CITY OF ALBUQUERQUE

June 15, 2020

**RE: 4600 Edith Blvd NE – SWMD Admin. Office and Vehicle Maintenance
Drainage Report (Engineer's Stamp 5/15/2020)
Hydrology File: G15D202**

JRMA Project No.
4907-B
W&C - 14-100-132-01
C-408

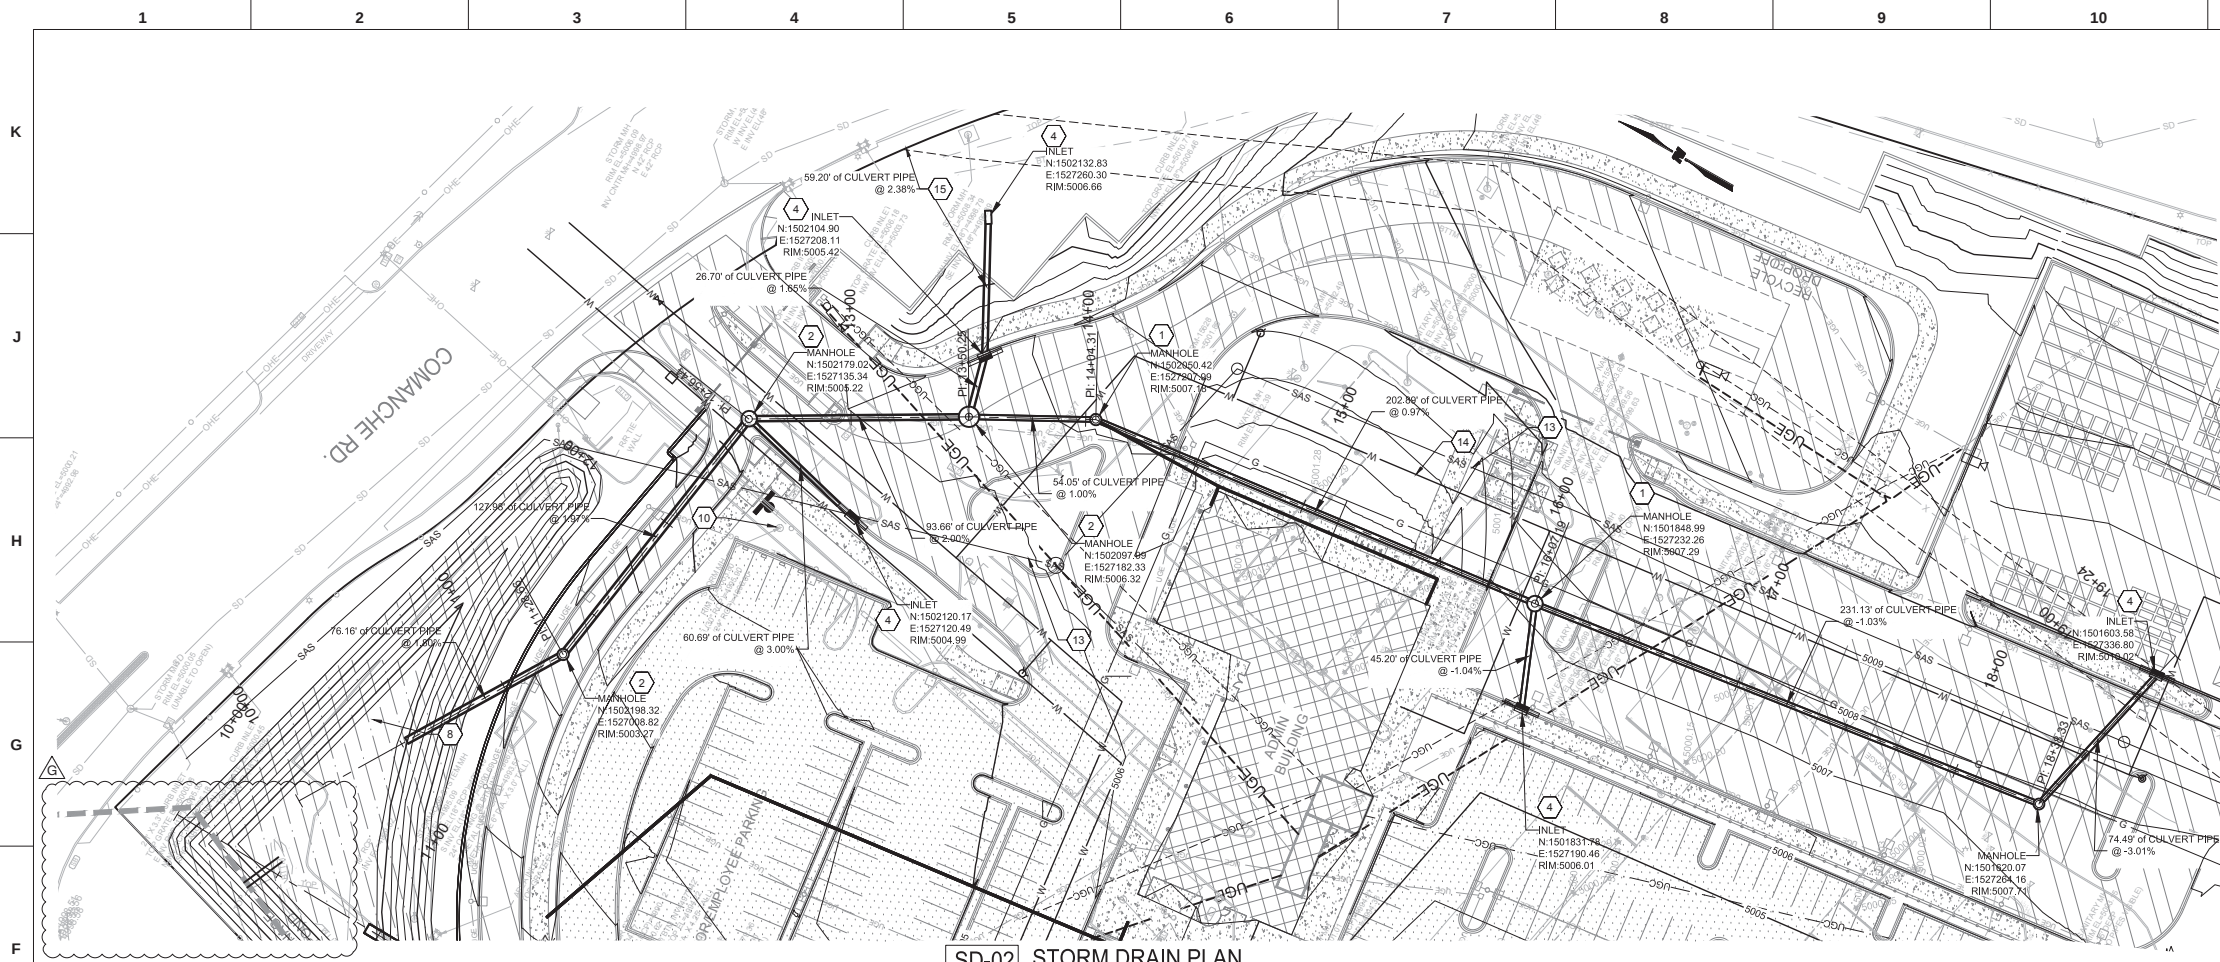
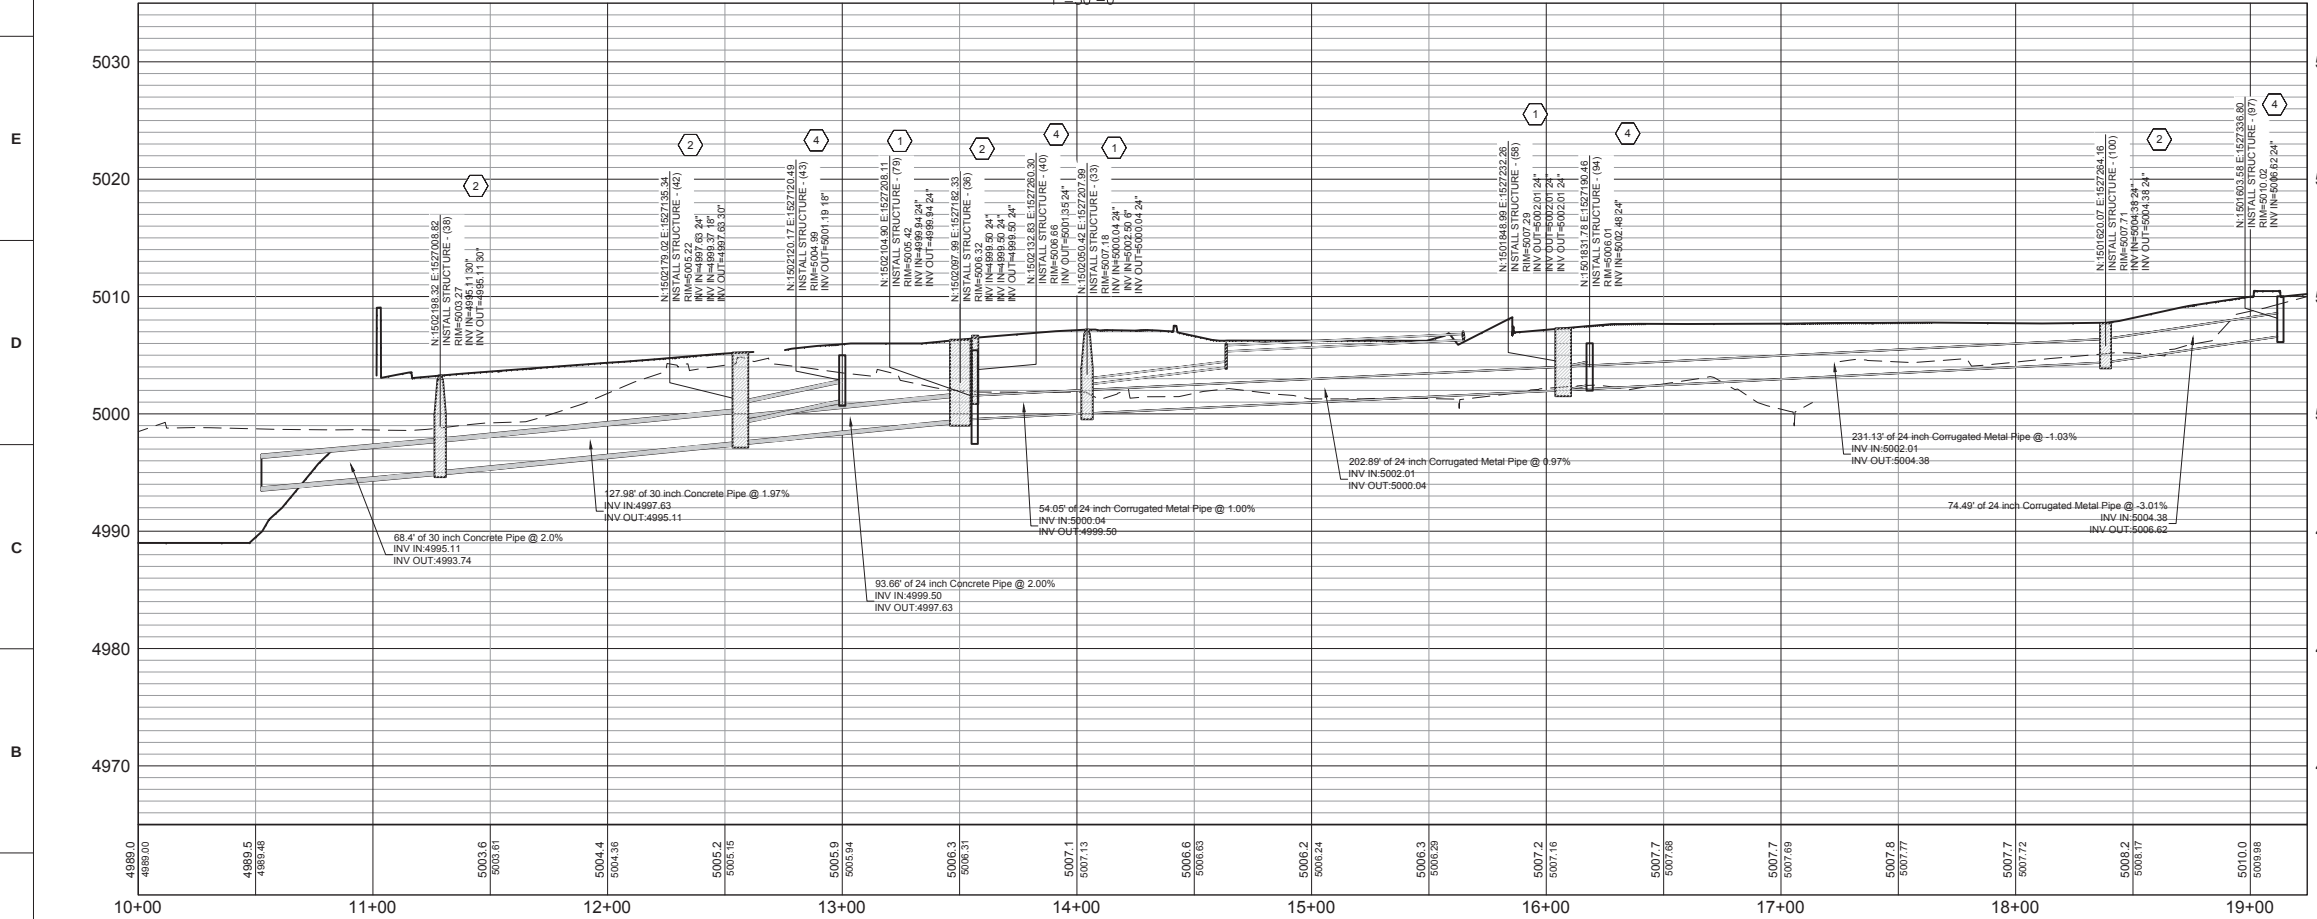
2. Sheet C-408: This sheet and the corresponding calculations in the report do not match with the Work Order plan set. This includes pipe lengths, slopes, HGL's, and velocities. Please determine which is to be used and make sure all calculations work with chosen layout.

- On Detail D5-01 please add roadway identification or call out on overall sheet to identify where this detail sits overall.
 - Add a north arrow to Detail SD-01 so not to confuse the orientation with Detail D5-01.

- Call out size and type of manhole on detail of SD-01.
 - Inlet structure (104) appears on the plan to be located in the middle of the road, but is called out as a Type "C" which has a curb inlet.

AS NOTED
DATE
DWG
JRMA Project No. 4907-B
W&C - 14-100-132-01
C-410

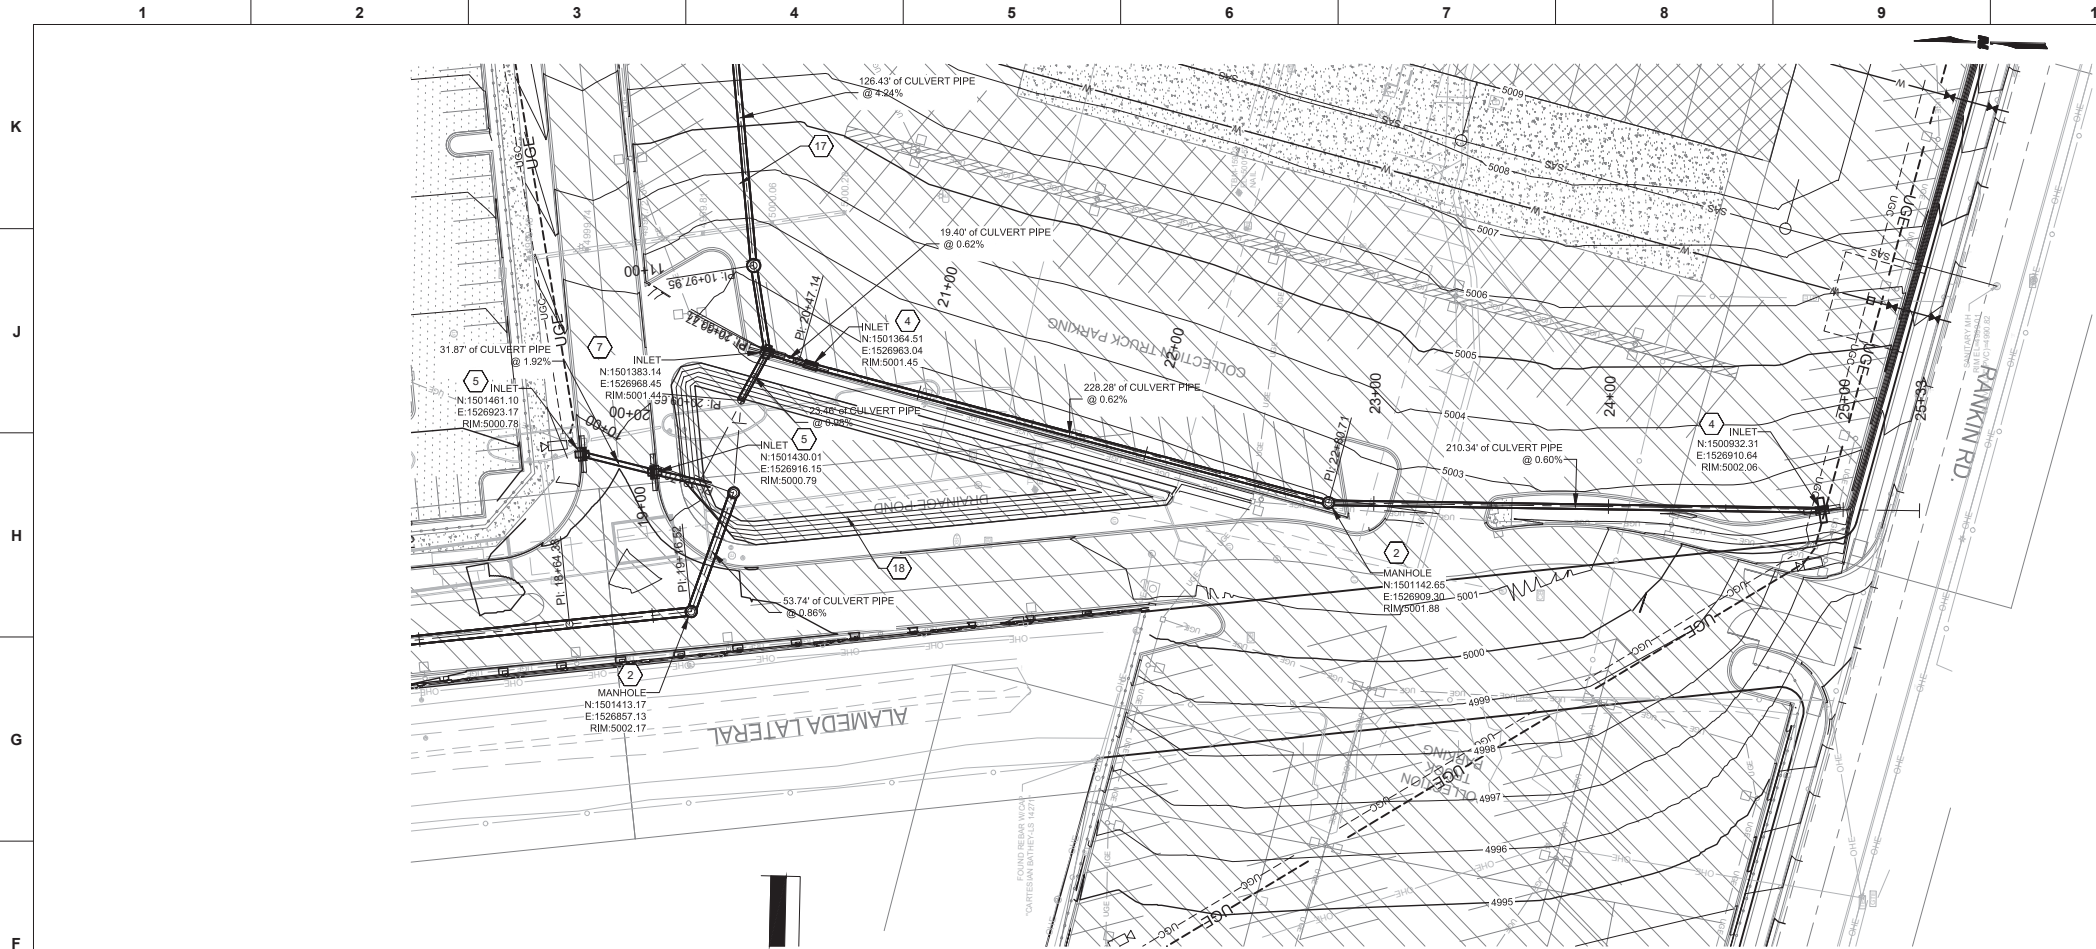
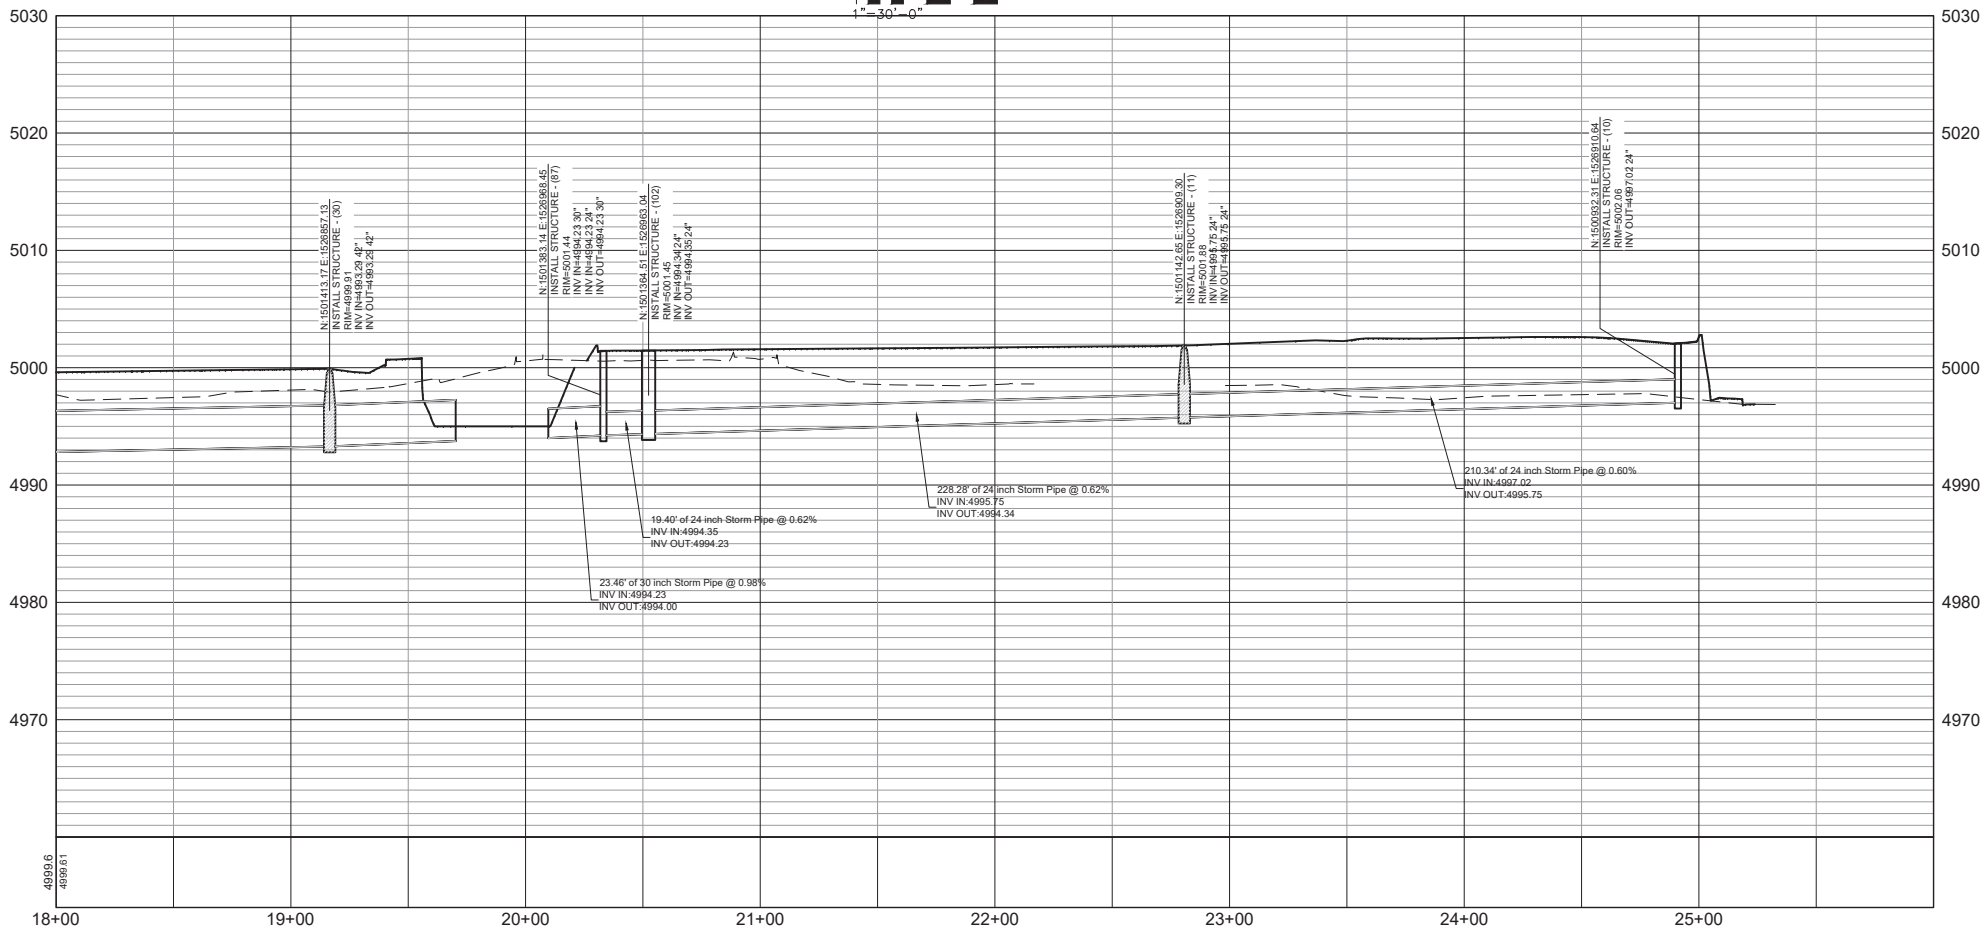
3. Sheets C-410 to C-412: Manhole and Inlet labels have not been added.
4. Please specify the Curb type/height on the G&D Plans. I see you added the calculation but the type and height need to be called out on the plans.
